## Application for a Non-Material Amendment Following a Grant of Planning Permission

Land south of South Side, Steeple Aston, Oxon.

Erection of 10no. two storey residential dwellings with access off South Side including a new pedestrian footway, parking and garaging, landscaping and all enabling and ancillary works.

22/01788/F

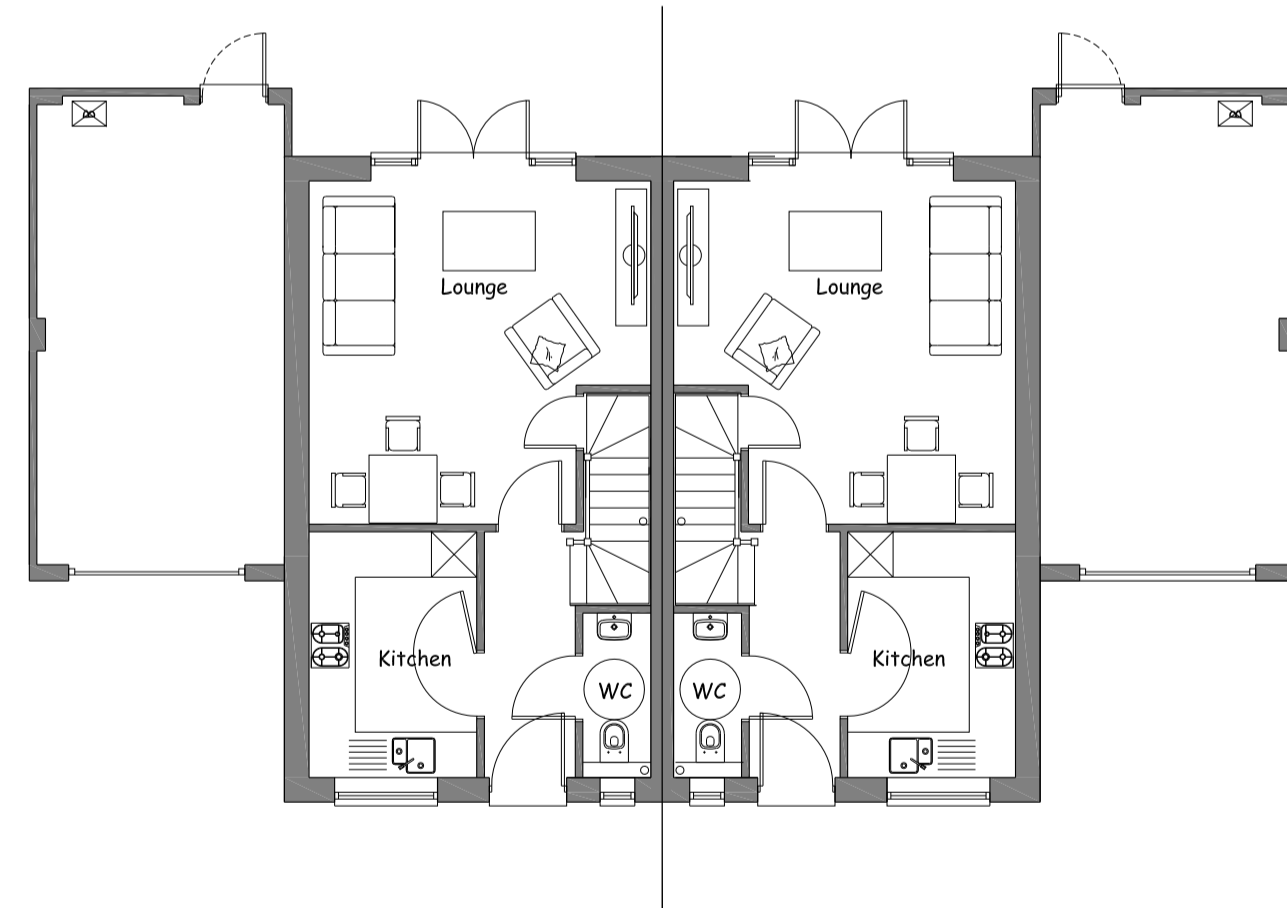
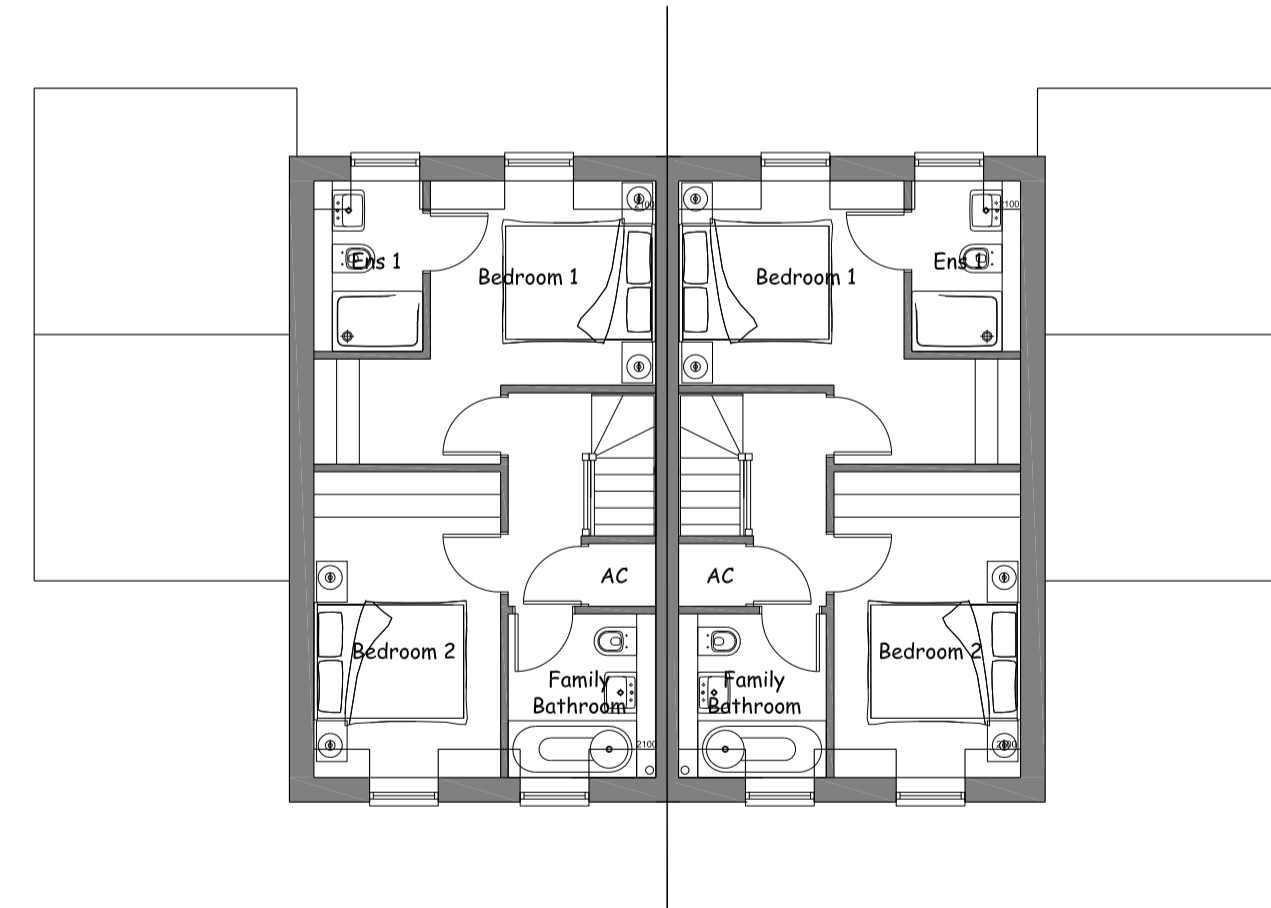
Non-material amendment to show a 300mm difference in ridge heights between plots 8 and 9 due to the difference in finished floor levels.

To regularise the difference in finished floor levels of plots 8 and 9 as shown on approved plan 6355-MJA-SW-XX-DR-C-900 REV P3 of application 22/01126/DISC relating to discharge of condition 5 of application 21/02318/F.

P.224.SD.2B.754 Rev D
